Subject: Rezoning Petition Review

Rezoning Petition #: 22-049

Location of Property: Approximately 9.84 acres located on the south side of Old Dowd Rd, west of I-485 and south of Wilkinson Blvd.

**Recommendations
Concerning Storm Water:**

**CONCEPT PLAN - L-2**

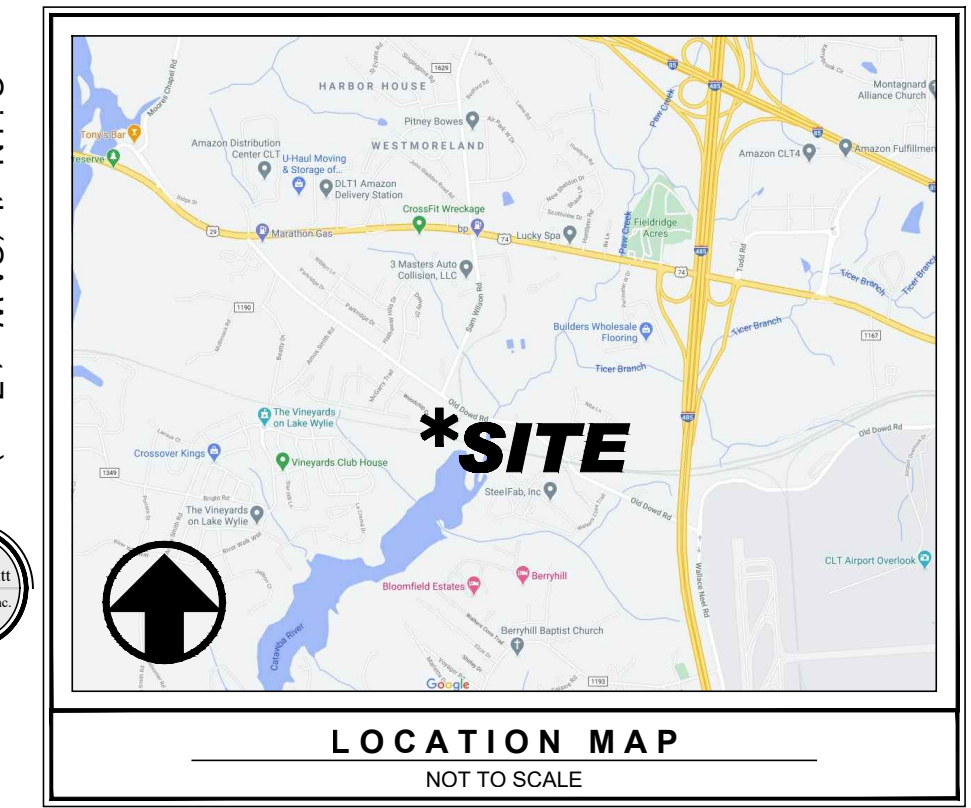
Please include the following note under *Environmental Features*: Development within any SWIM/PCSO Buffer shall be coordinated with and subject to approval by Charlotte-Mecklenburg Storm Water Services and mitigated if required by City ordinance. Petitioner acknowledges intermittent/perennial stream delineation reports are subject to review and approval upon submission of development plans for permitting and are not approved with rezoning decisions. The existing pond on site may require a buffer depending on results of the delineation report.
